**Preliminary Approach to Respond to Public Comments on the Conditional Use Permit (CUP) Application and State Environmental Policy Act (SEPA) Checklist for the
Teanaway Solar Reserve Project**

FIGURE 4
Proposed Site Layout
 Teanaway Solar Reserve
 Kittitas County, Washington

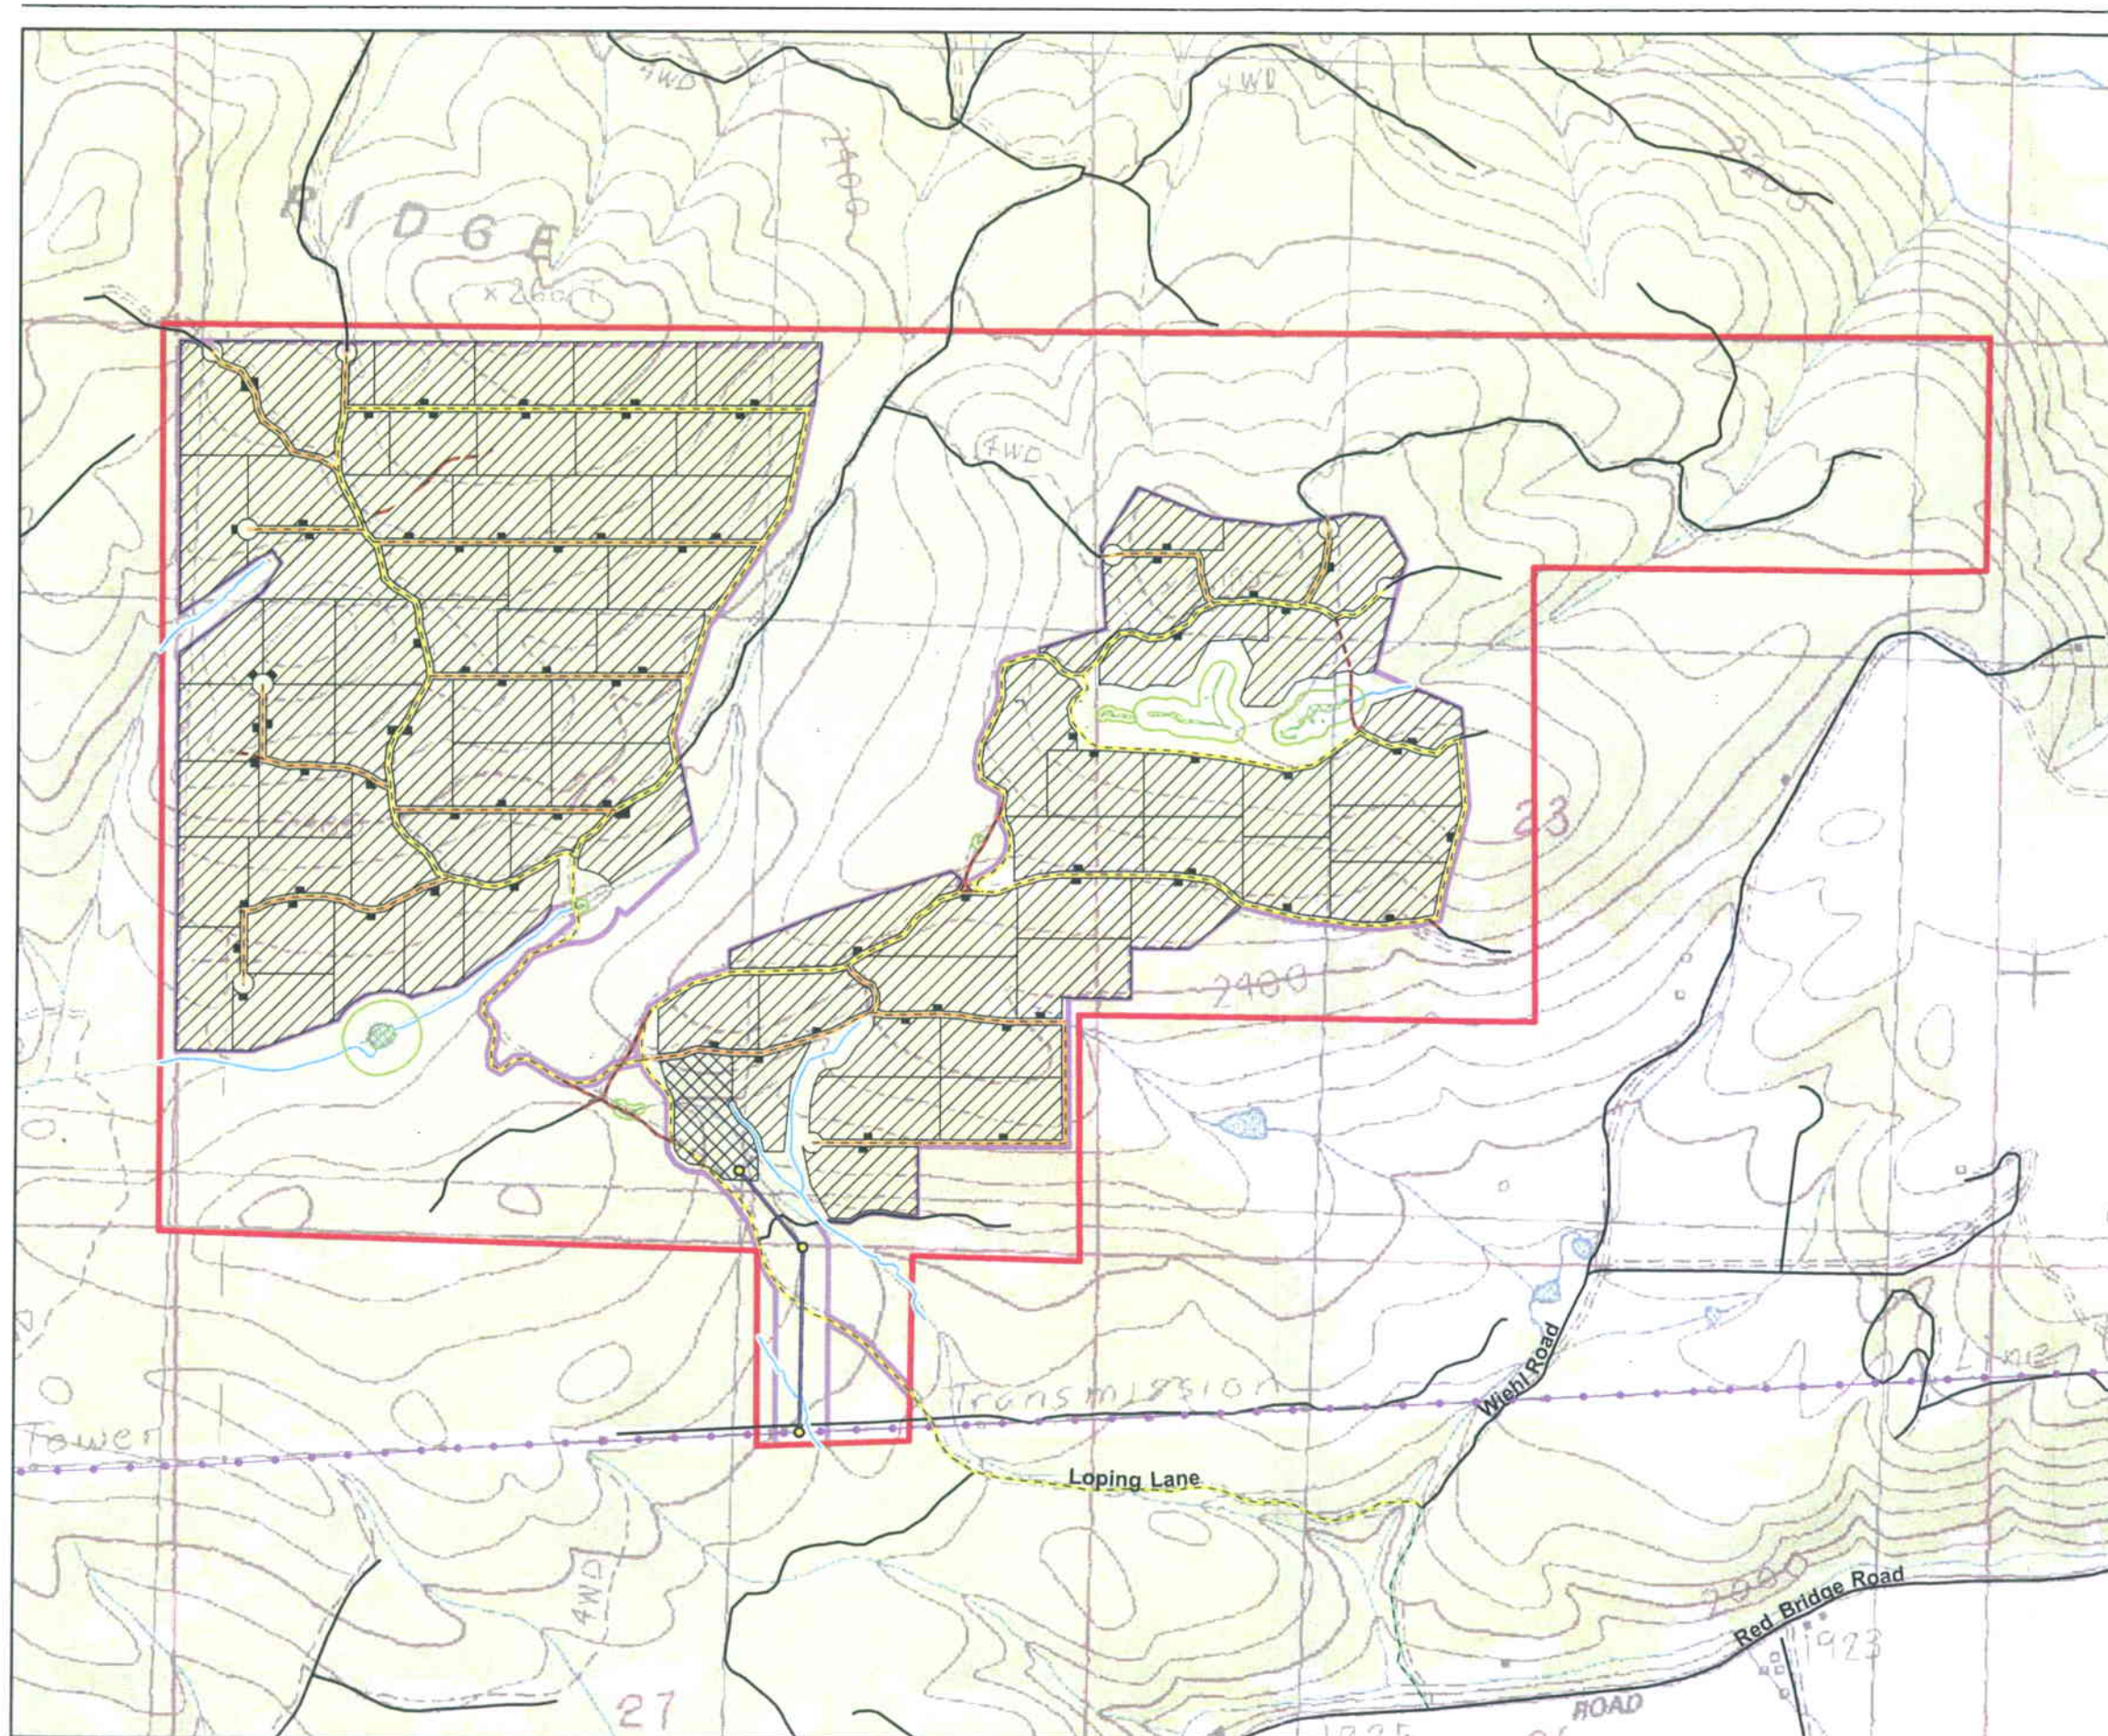
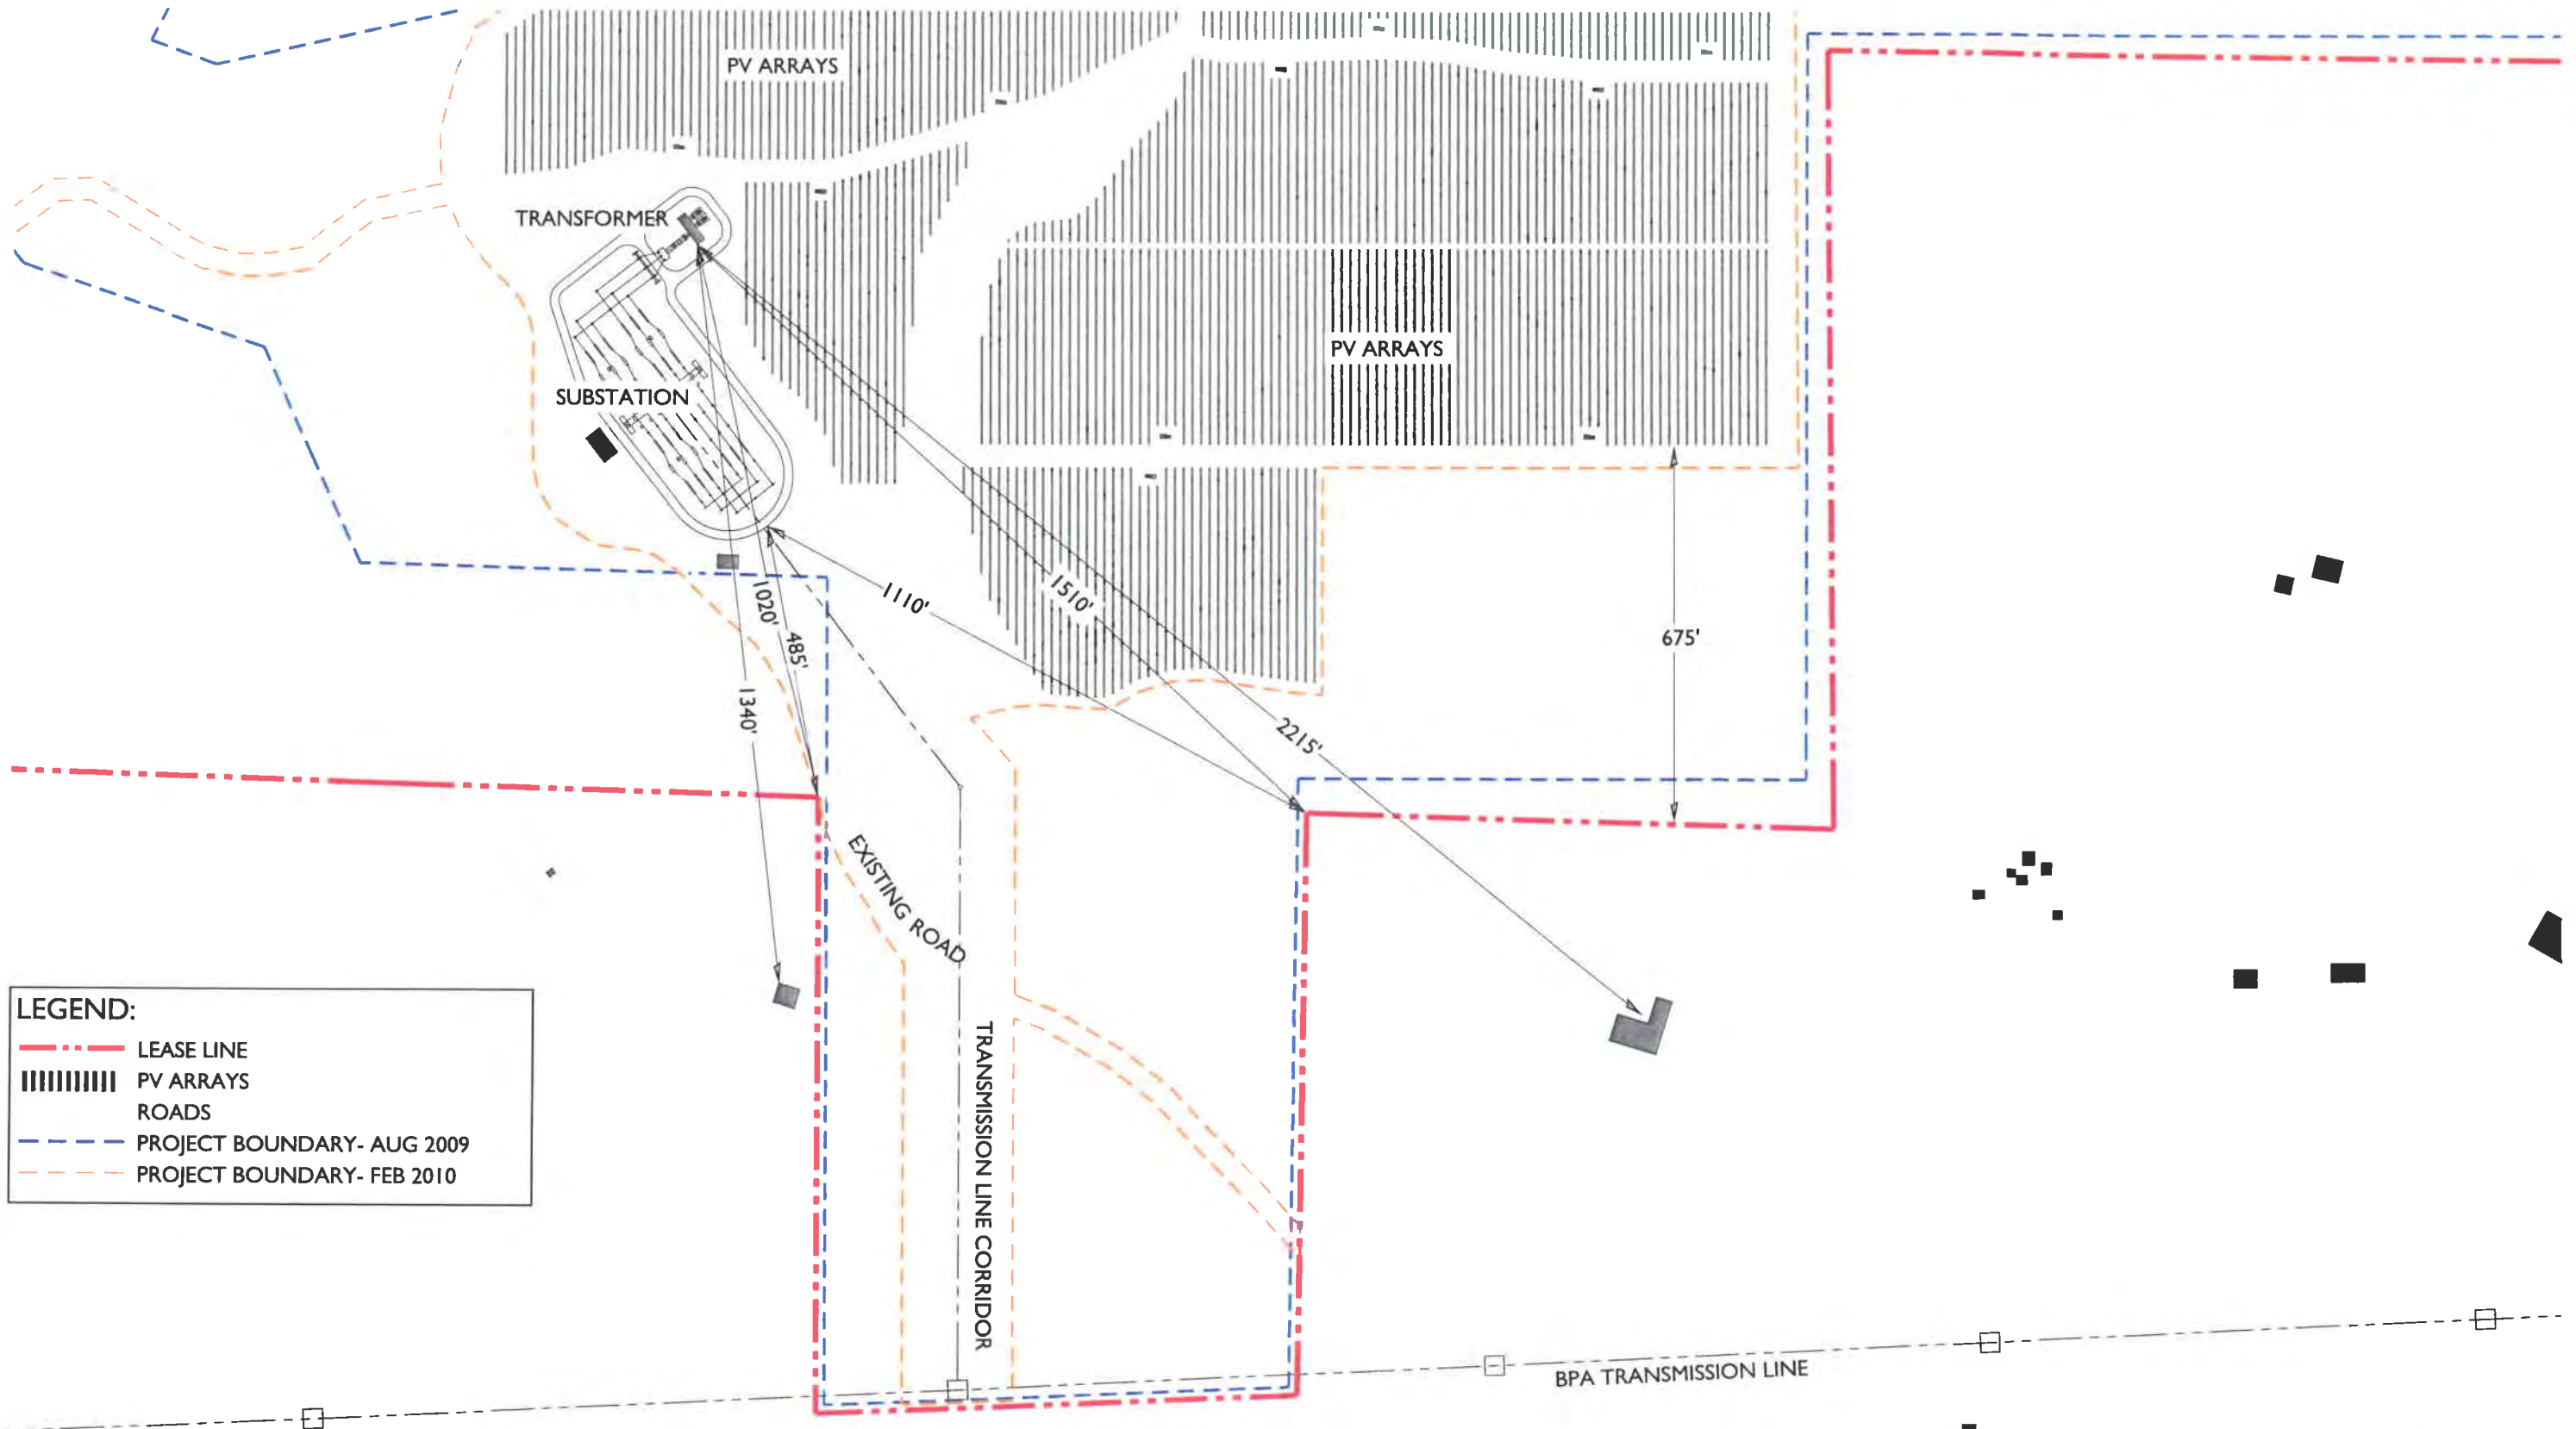
Comment 25	Proposed setbacks	Land Use and Shoreline	Charles Adams General Manager Pine Hills Ranch LLC	September 17, 2009	Applicant has only provided "conceptual" view of the project which includes a 500 ft setback along our joint property line. There is no way to determine if this setback is adequate to mitigate impacts to our property. Would like to see "a larger setback to shield our property from some of the negative effects of the project but also to provide a buffer and corridor for deer, elk and other wildlife to move up the slope to the north facing areas of the site". Applicant shows 100 foot setback along portions of the southern boundary. "This minimum setback seems unreasonable in light of its direct visual impact." See Attachment 5 for complete letter.	The Applicant is working with concerned landowners to devise potential alternatives and mitigation measures to further ensure against visual or detrimental impacts to character of surrounding area. The applicant will comply with all firebreaks, as mandated by the county. To maximum extent practicable, fire break shall be constructed to minimize impacts to existing vegetation and bordering trees. The applicant will develop a vegetation plan to address impacts from construction and on-going operations. Alternative migratory routes for wildlife and the potential impact on wildlife, particularly large game (elk, deer) will be presented in greater detail in the Applicant's additional information.	No
